EL PASO COUNTY  
 SPECIAL PERMIT BY USE SUBMITTAL  
**MONUMENT STEEL STRUCTURES**  
 18910 BASE CAMP ROAD  
 MONUMENT, COLORADO

# Sign Plan\_v1-redline.pdf Markup Summary

SECTION THRU PROJECT SIGNAGE

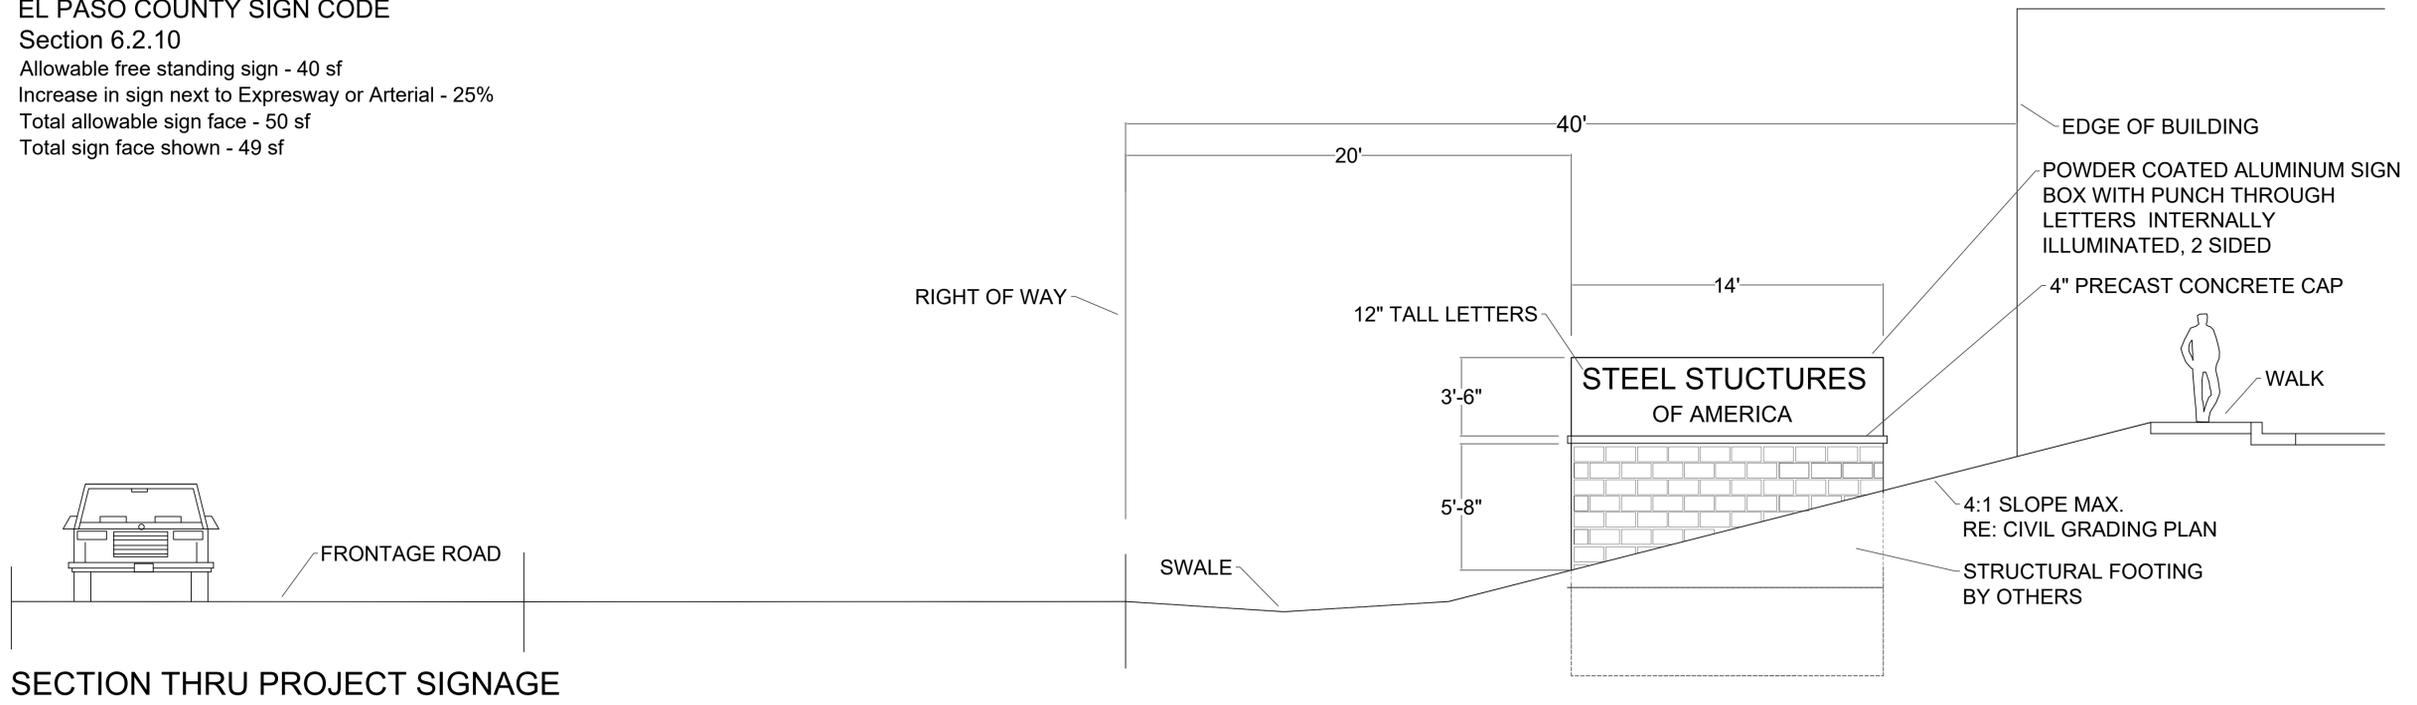
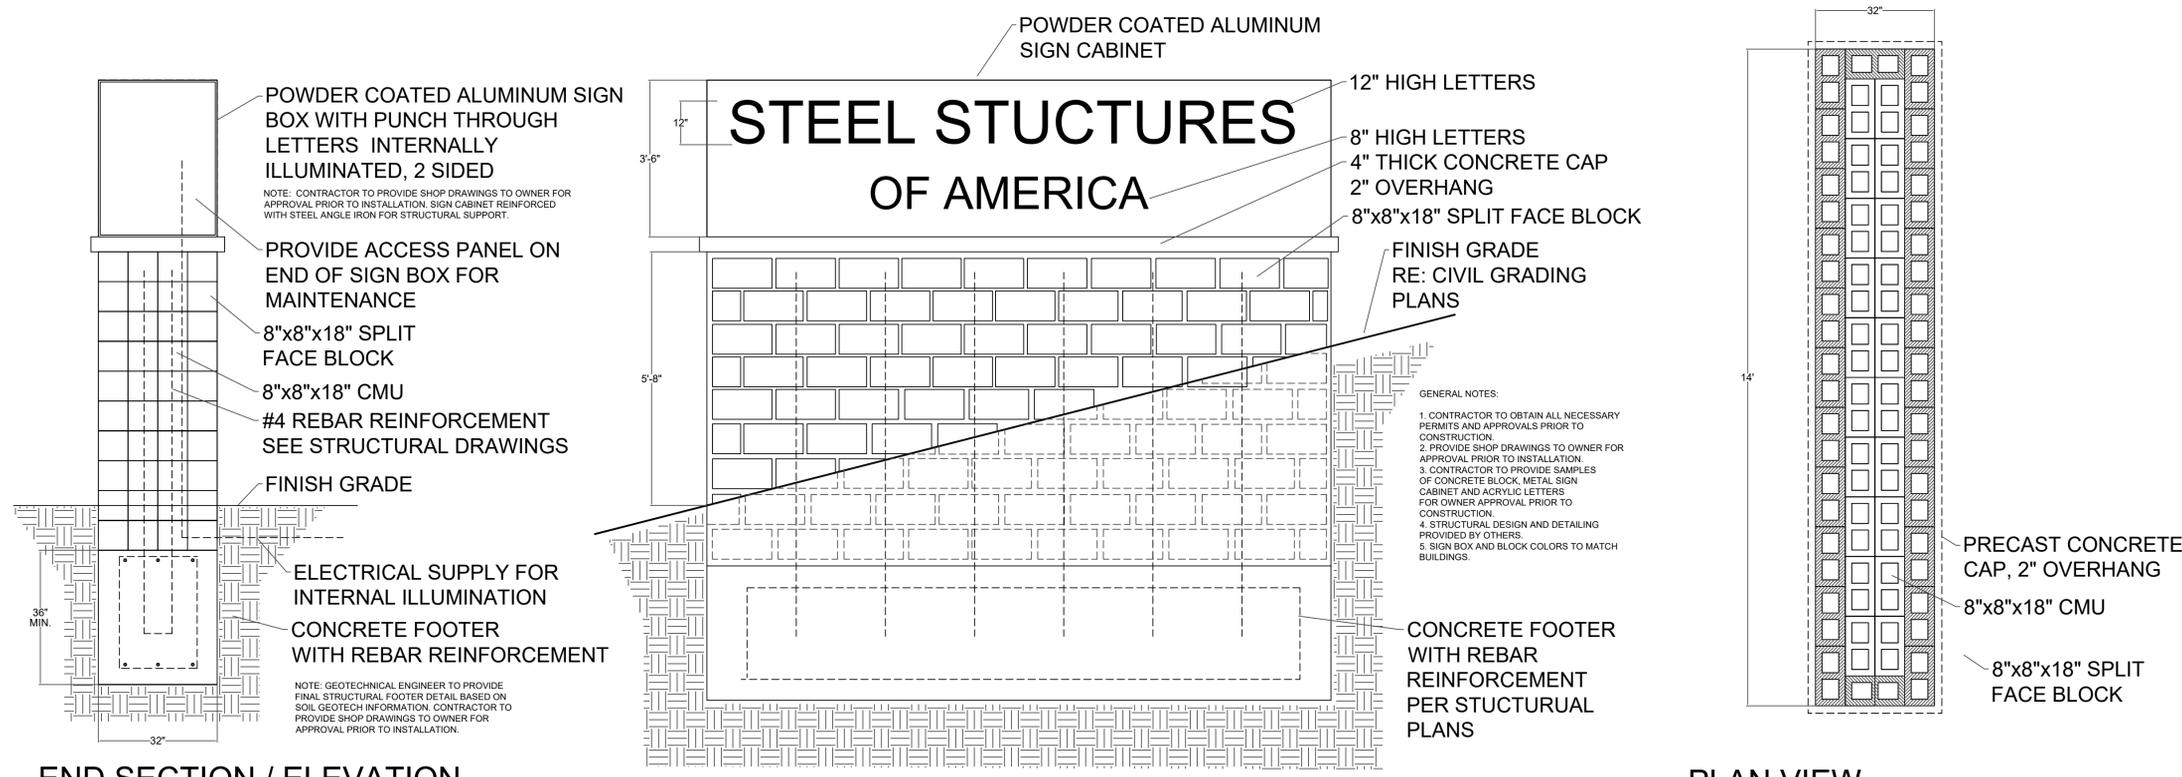
Show the location of the monument sign in the site plan.

Separate sign plan required.
